From: Contact Centre (CRM) <contact@ribblevalley.gov.uk>
Sent: 12 December 2024 18:28
To: Planning
Subject: Planning Application Comments - 3/2024/0911 FS-Case-670194333

Planning Application Reference No.: 3/2024/0911

Address of Development: Hough Clough Farm
Houghclough Lane, Chipping,
Preston
PR3 2NT

Location Plan

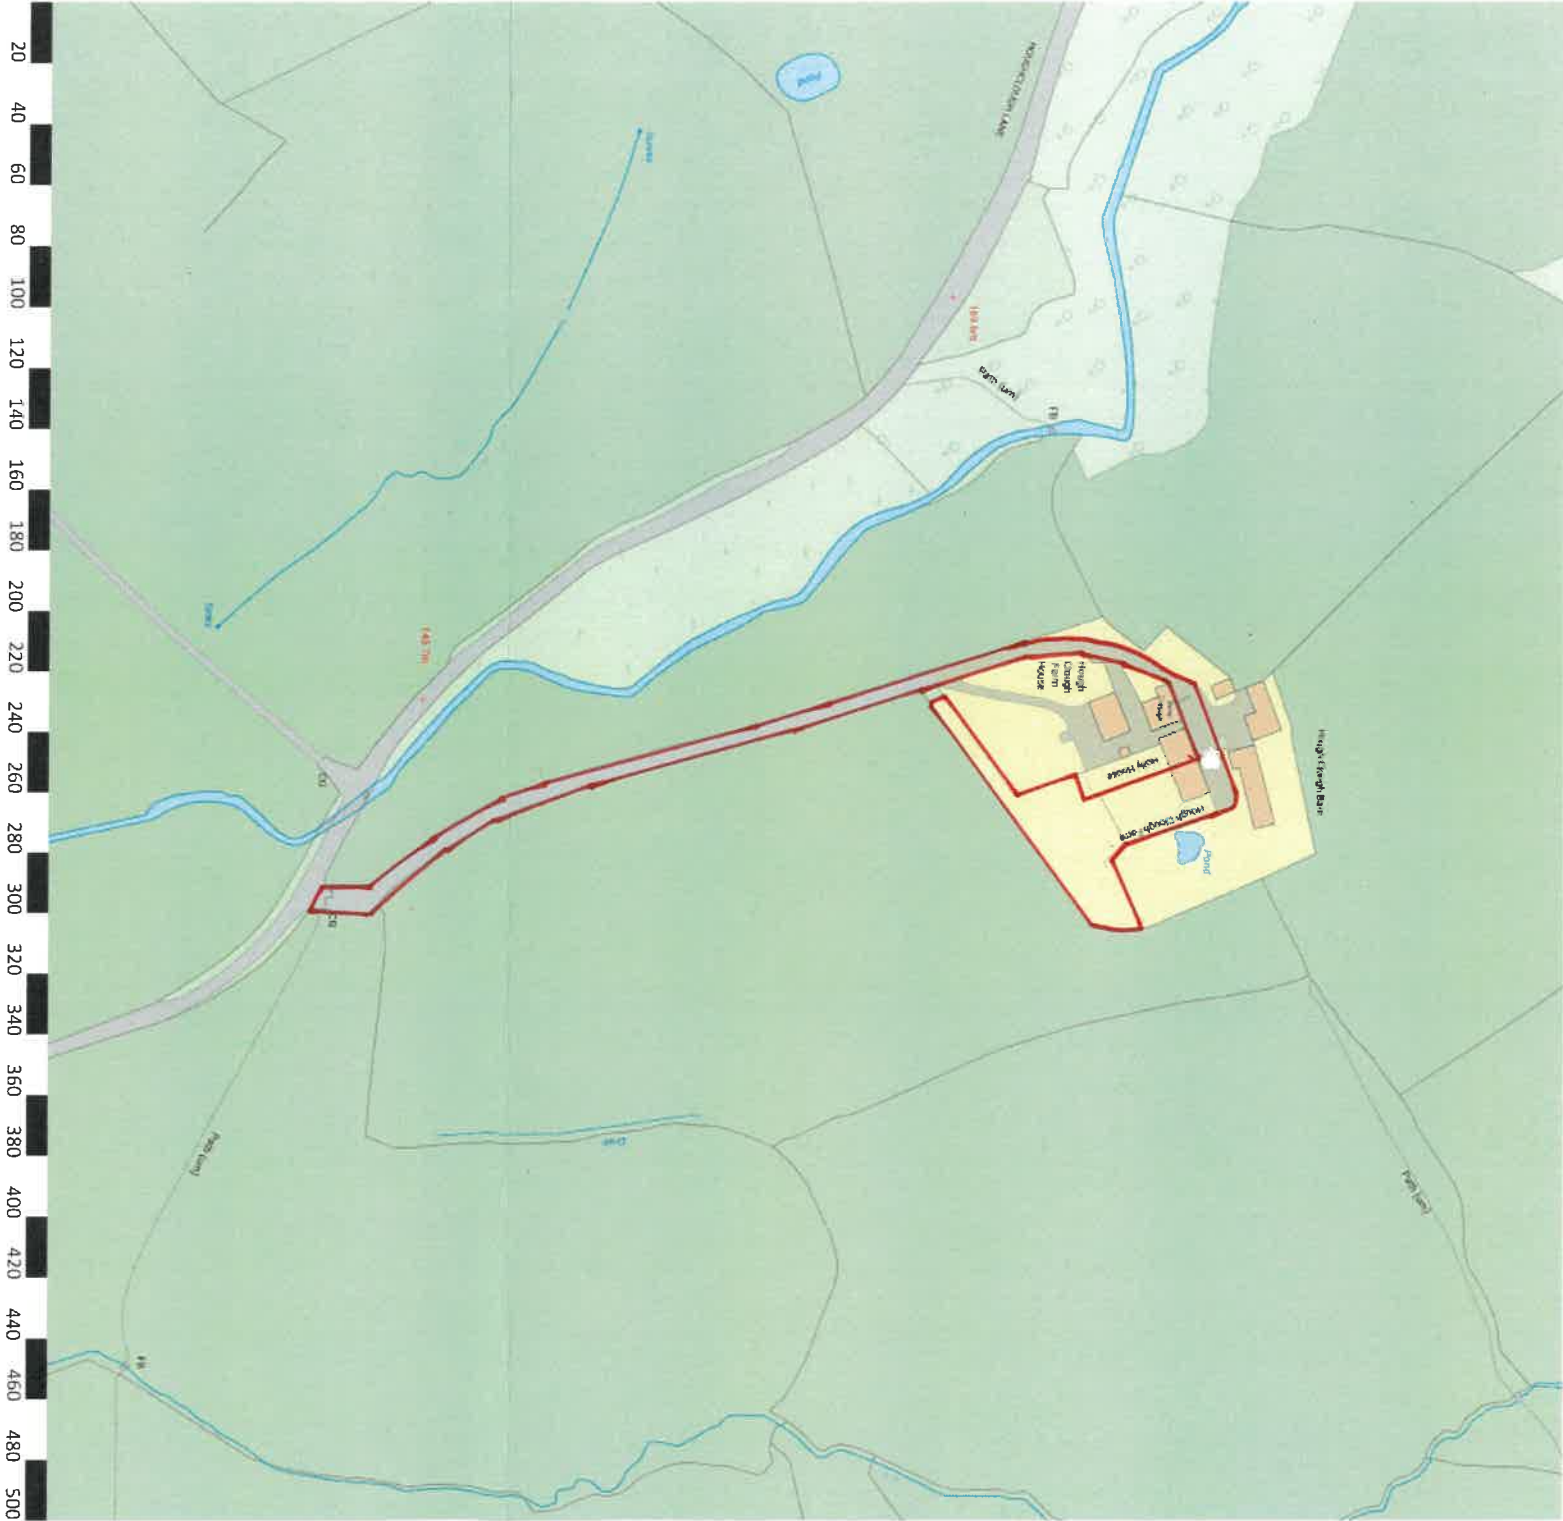
Comments: 1) The red line that shows the property boundary on the Location Plan is incorrect as it should not include the access drive. [REDACTED].
2) I feel that the picture window on the East elevation is excessive (over 3m wide and floor to ceiling). This is within 1.2m of the boundary [REDACTED]. I would expect privacy to be observed by using minimal windows, high up and using obscure glass on the eastern elevation.
